I note the objection from the Environmental Health Officer and would like to provide the following comments to address concerns.

The comments relate to the lack of information in accordance with the conditions set out in the Appeal Decision, notably conditions 4, 17 and 18, these are summarised below:

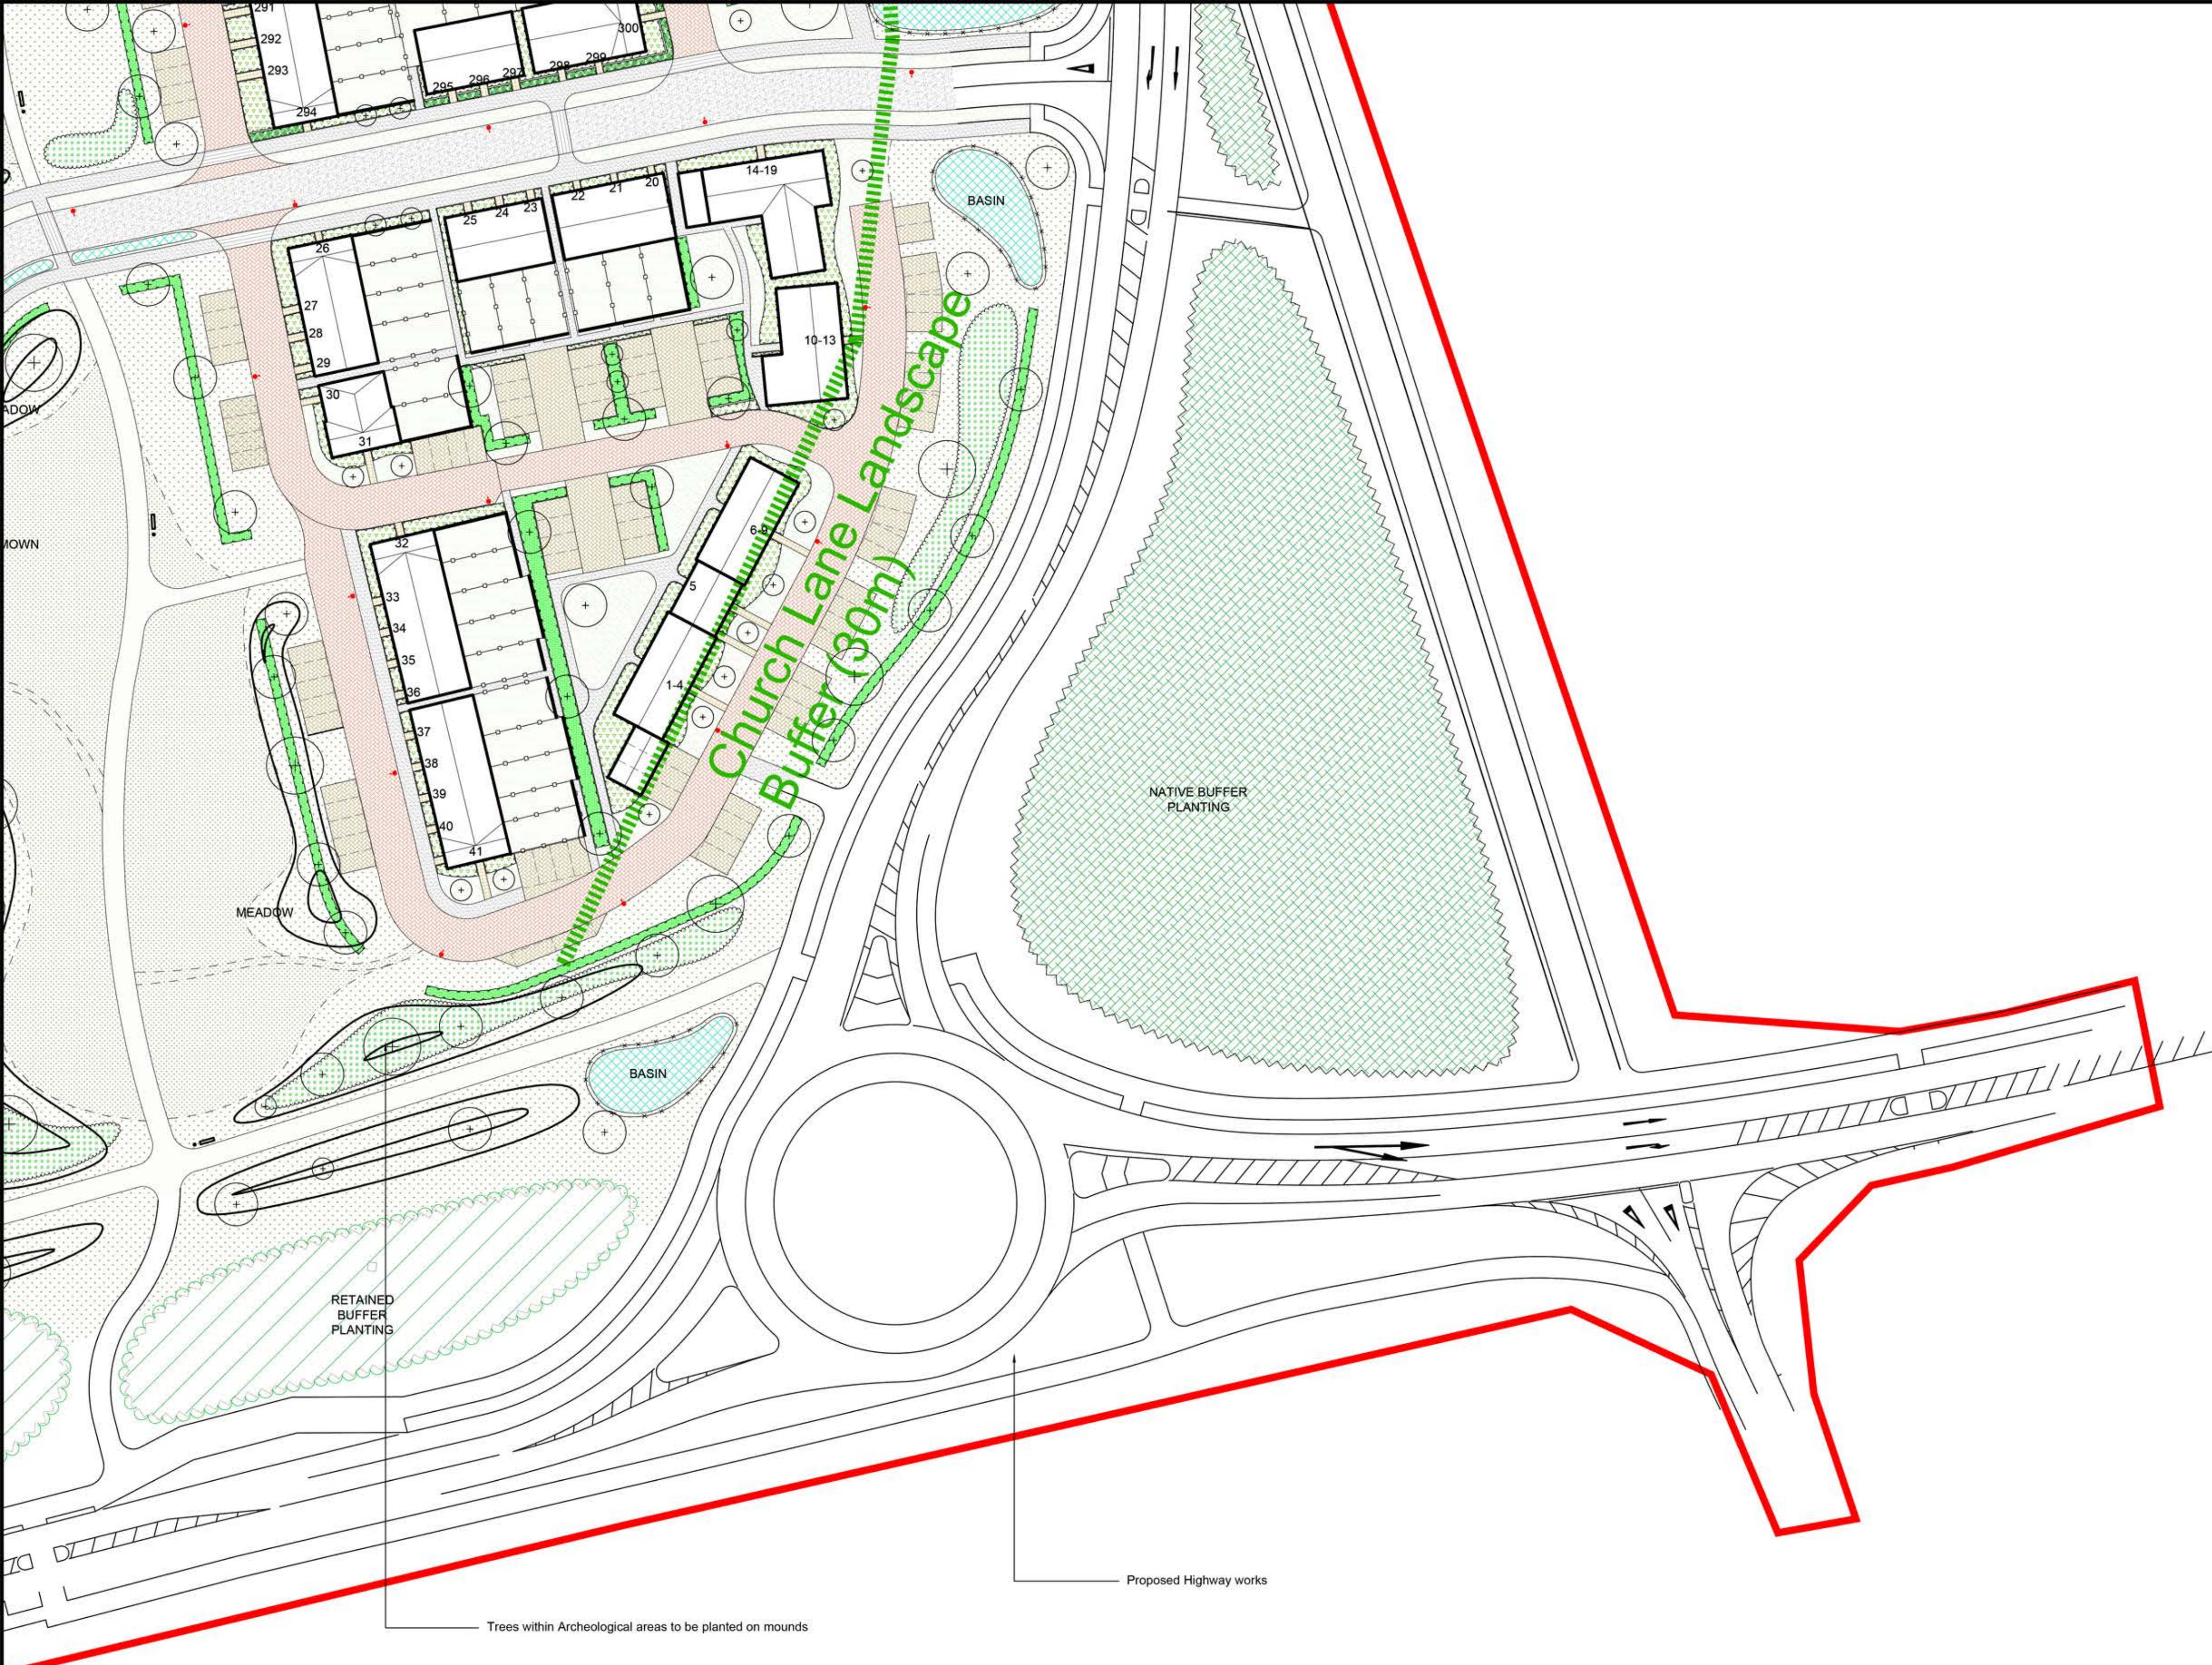
Condition 17 – **no development shall take** place until details of an acoustic barrier as shown on the plan with associated tree and shrub planting has been submitted to and approved in writing by the LPA.

The site plan, subject to this reserved matters application has been revised and includes changes to the layout along the southern boundary. The noise mitigation strategy has evolved to address the new arrangement as the permitted scheme is no longer appropriate. The bund was proposed as a mitigation measure to reduce the noise levels in the gardens, and not the dwellings. The dwellings now face onto the green buffer with the gardens on the northern side of the building. The dwellings consist mainly of semi-detached and terrace housing which act as a barrier and allow for protection of the gardens, the gaps in between the buildings will be defined by a 1.8m high fence to act as a barrier to the noise which can be experienced between the buildings.

Applicant's Response: The condition states "**no development**" this means there is not a requirement for this information to be submitted at this stage and can be conditioned if needed. We will however, be providing details of tree and shrub planting that will be incorporated on the bund to address this condition. These details will be part of the outstanding planting plans.

A noise barrier will be provided along the southern boundary which has been considered acceptable for this development. The gardens will be screened by the relevant houses and fencing and the specific acoustic glazing and acoustically treated ventilation will be incorporated in each house as set out in the noise assessment.
